Mr & Mrs R D Harris,
8 Fosters,
Fosters Close
East Preston
BN16 2TT.

15th January 2018.

Re: Proposed new installation of bi-fold doors and panels to enclose balcony.

FLOOR PLAN
FOSTERS
FOSTERS CLOSE
ANGMERING LANE
EAST PRESTON
LITTLEHAMPTON
WEST SUSSEX
BN16 2TT

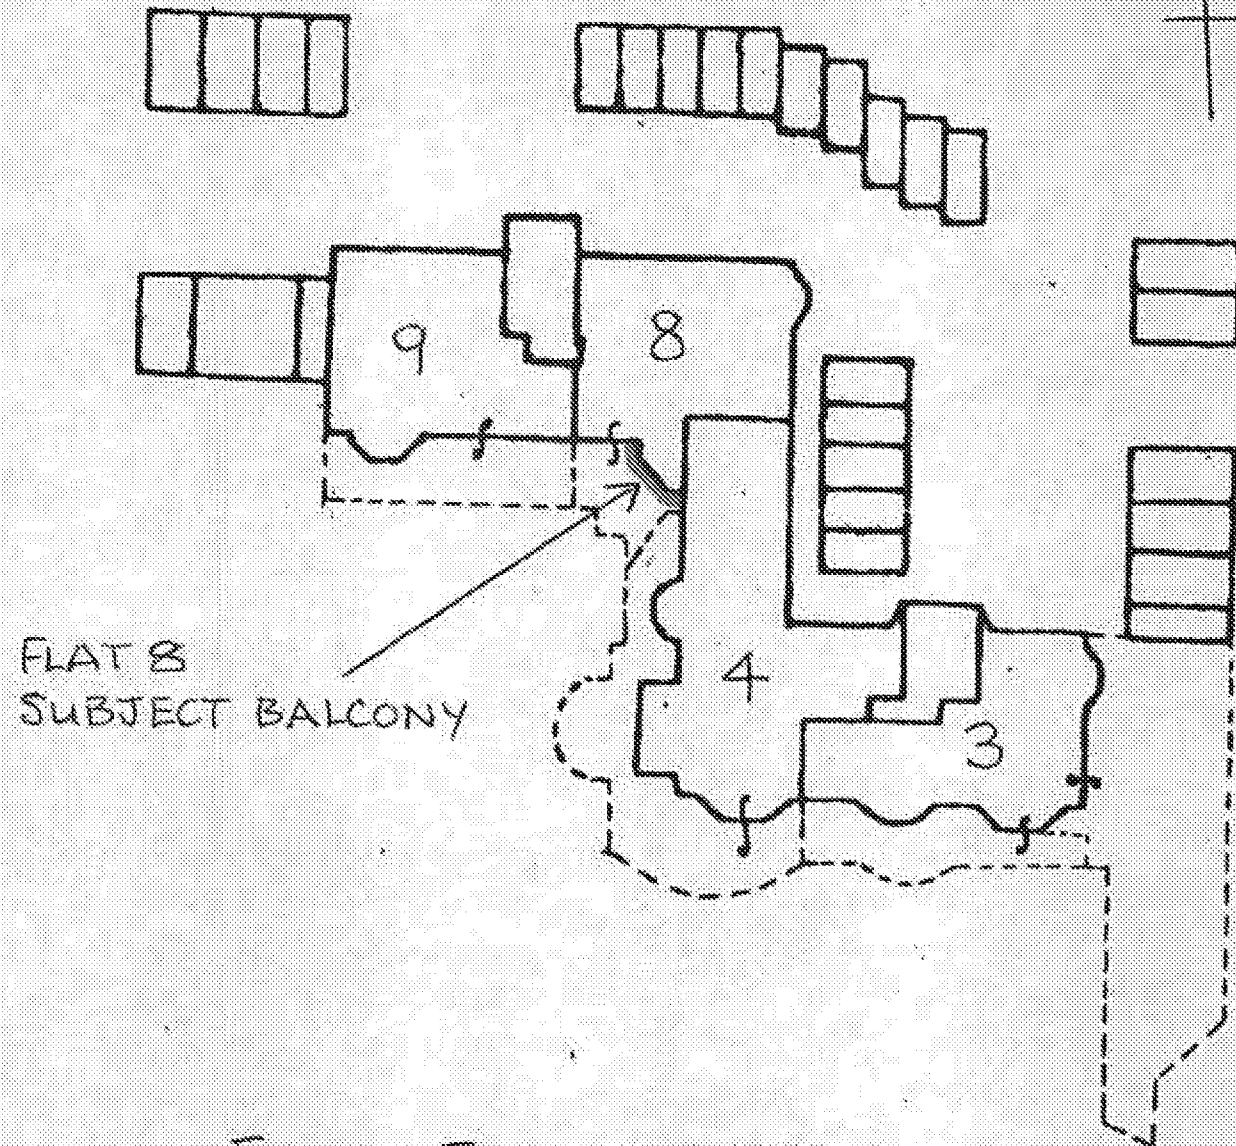
- The proposal fully encloses an open balcony. This alteration may require Planning Consent and an enquiry should be made to the Planners to ascertain. It would be wise to obtain written confirmation if Permitted Development applies.
- Aesthetics; The Visofold 1000 bi-fold doors and Visoline fixed panels are contemporary style factory-finished aluminium frames with mitred joints at the corners. The Visofold 2000 is available, which has square-cut joints at the corners which mimic the appearance of timber sections. This style may be more appropriate. No finish colour is given on the product details provided. The frames should be white, colour matched to match the white painted joinery.

- The design and installation of the whole of the proposed screen will need to comply with the Building Regulations. I advise that the designer / installer must make a Building Regulations Application and liaise with the Local Authority Building Control Dept to obtain Building Regulations approval for this proposed balcony screen. (Note, FENSA certification enables self-certification by the designer / installer of compliance with the Building Regulations in respect of replacement doors and windows, however, this proposal is not replacement).
- The guarding balustrade panels will need to comply with Part K2, Section 3: Protection from Falling, in particular 3.2 Design of Guarding, which requires;

- (a) The guarding balustrade will need to be a minimum height of 1100mm overall.
(b) The guarding balustrade must resist the loads given in BS EN 1991-1-1 and PD 6688-1-1.
- The sufficiency of the existing steel corner post and its fixings should be proved within the design details.
 - Glazing will need to comply with Part K2 Section 5, which requires the use of safety glass and that the glass must break safely.
 - The doors / screen will need provisions that maintain the existing ventilation provisions of the property.
